FG/111/07**PLANNING APPLICATIONS REPORT**

DESCRIPTION/ ADDRESS	- Single storey extension to form garage and alterations to provide carers accommodation. (Re-submission following application FG/61/06). 2 Herm Road, Ferring.
-------------------------	--

BLOCK PLAN
SCALE 1/500

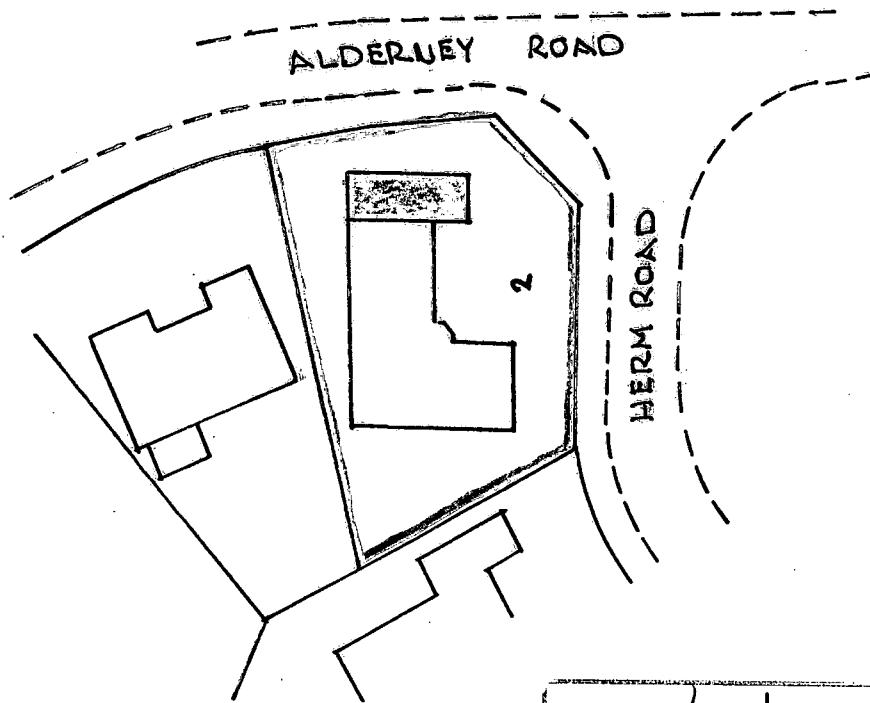
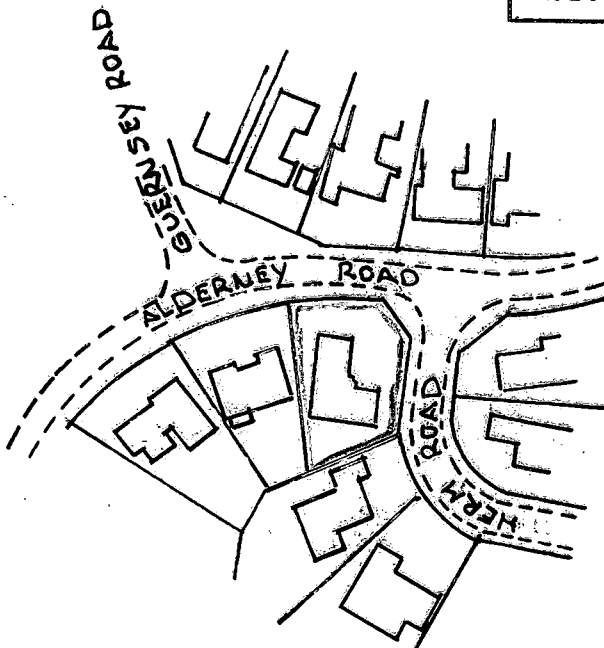
The current proposal has sought to remove the boundary wall and railings and has reduced the width of the extension from approximately 5.6m to 4m. The extension will leave a resultant gap of a minimum of 4m between the extension and the pavements edge. This will be one of the shortest distances between the side or front elevation of the properties in this section of Herm Road and the streets edge. Neighbouring properties number 1 and 3 Herm Road have a minimum gap of 6m, number 10 Alderney Road a 6.5m gap and number 12 Alderney Road a 6m gap; the remaining gap at number 2 Herm Road is therefore only approximately 2m less than the aforementioned neighbouring properties.

SOUTH ELEVATION

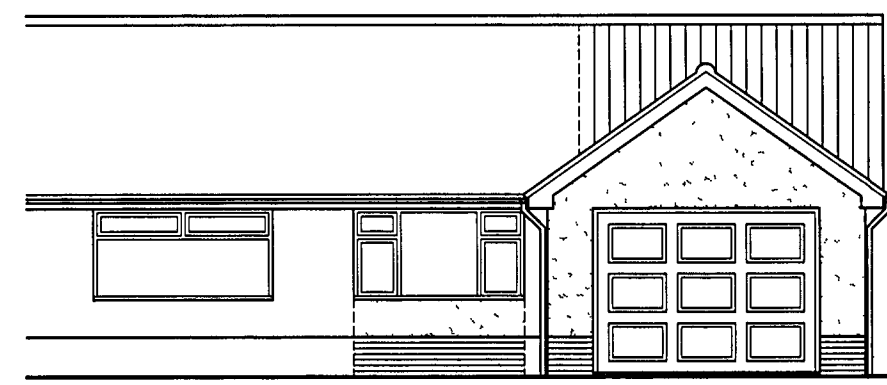
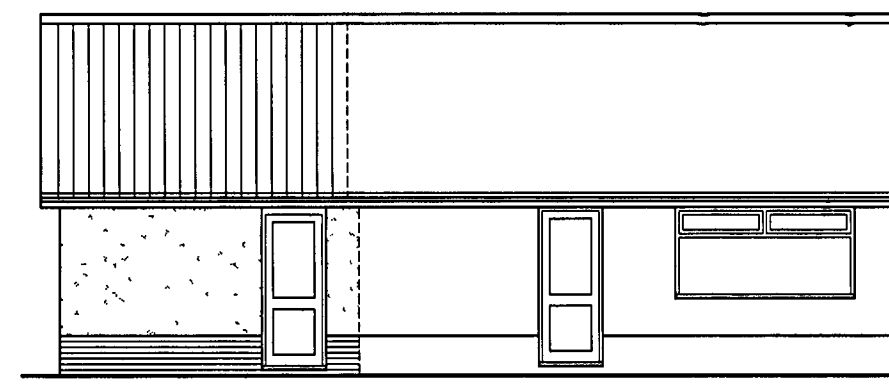
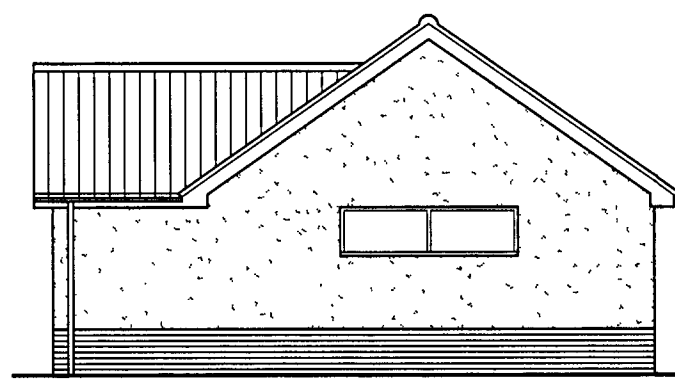
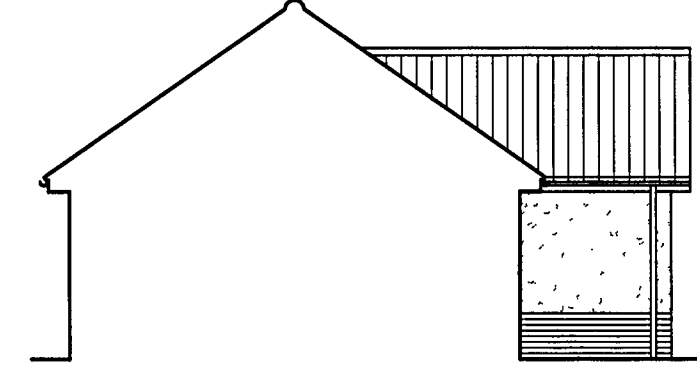
The extension is considered to be of an appropriate scale and design within the context of the property and the surrounding plot size. The maximum height does not exceed that of the main dwelling and the pitched roof over the front portion of the garage has been stepped down by 0.6m from the main ridge height. The increase in the footprint and volume of the property is considered to maintain visual subservience.

BLOCK PLAN
SCALE 1/500

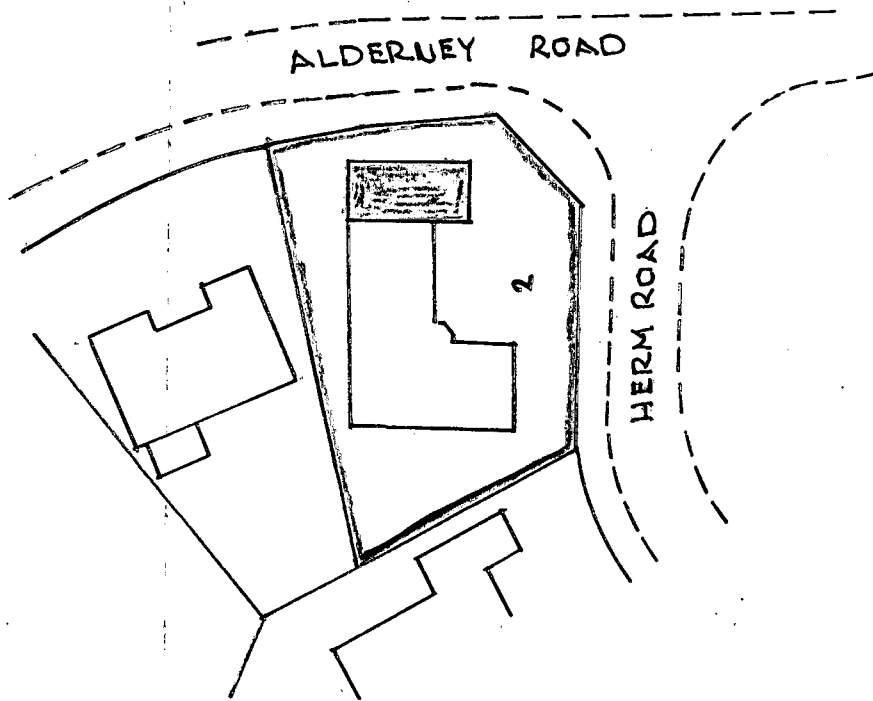
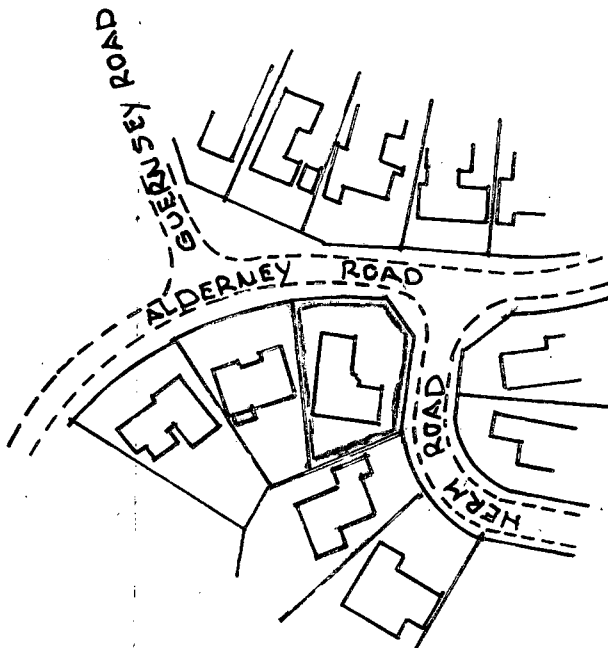
3. This permission relates to the plans as submitted and amended by substitute site plans dated 22nd August 2007.
